Our ref: Huntlee New Town - Stage 2 (SSD-70748466)

11 October 2024

Subject: Response to Submissions

ONRC-C04.01

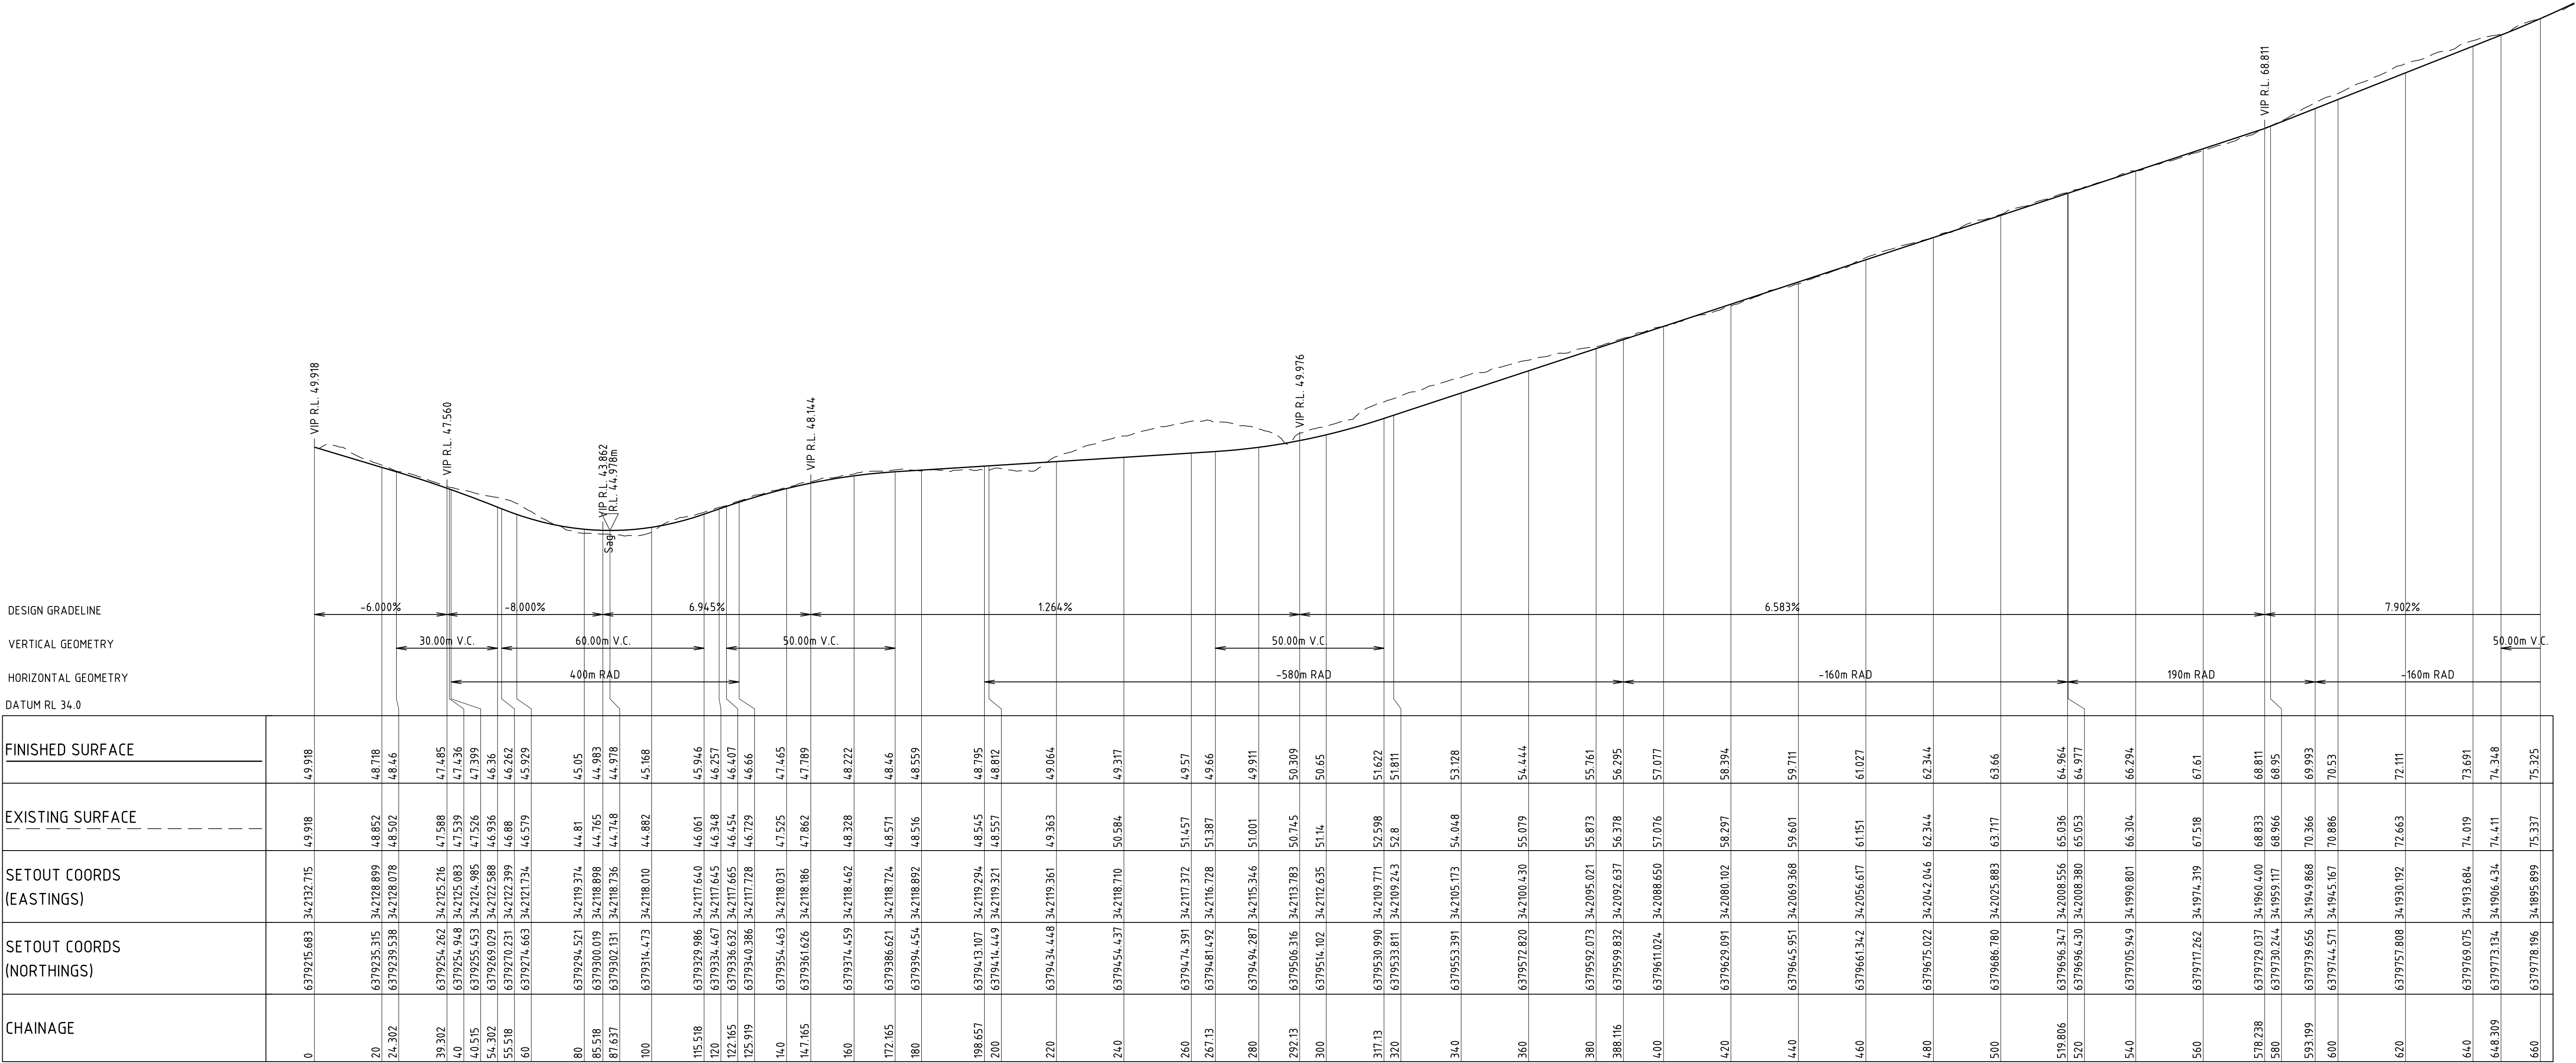
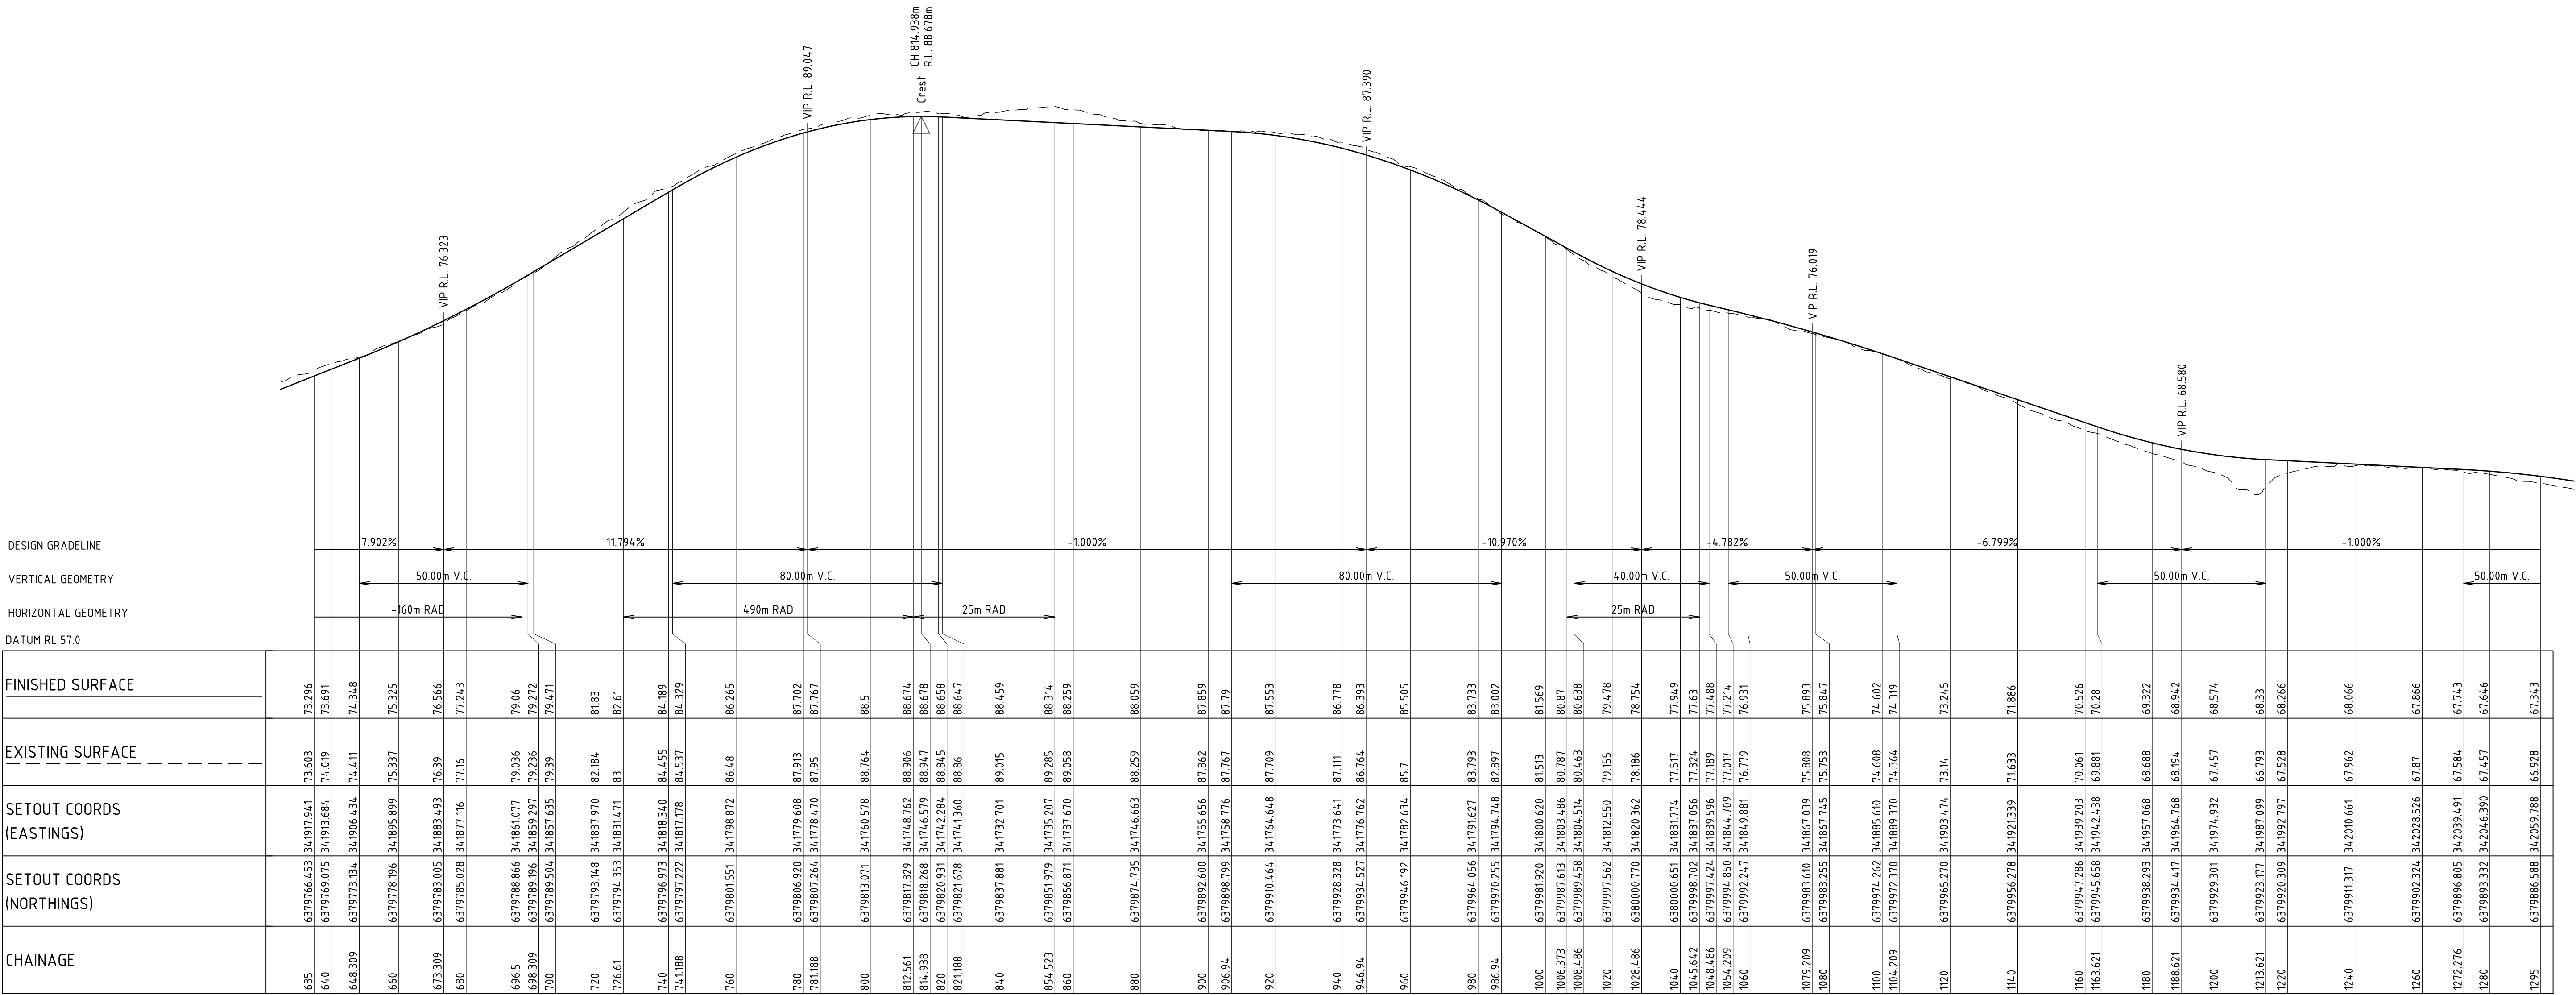
There are inconsistencies in the lot numbers and layout between the civil design plans and the subdivision plans.

- revised Civil Design Plans that have a consistent lot layout with the subdivision plans
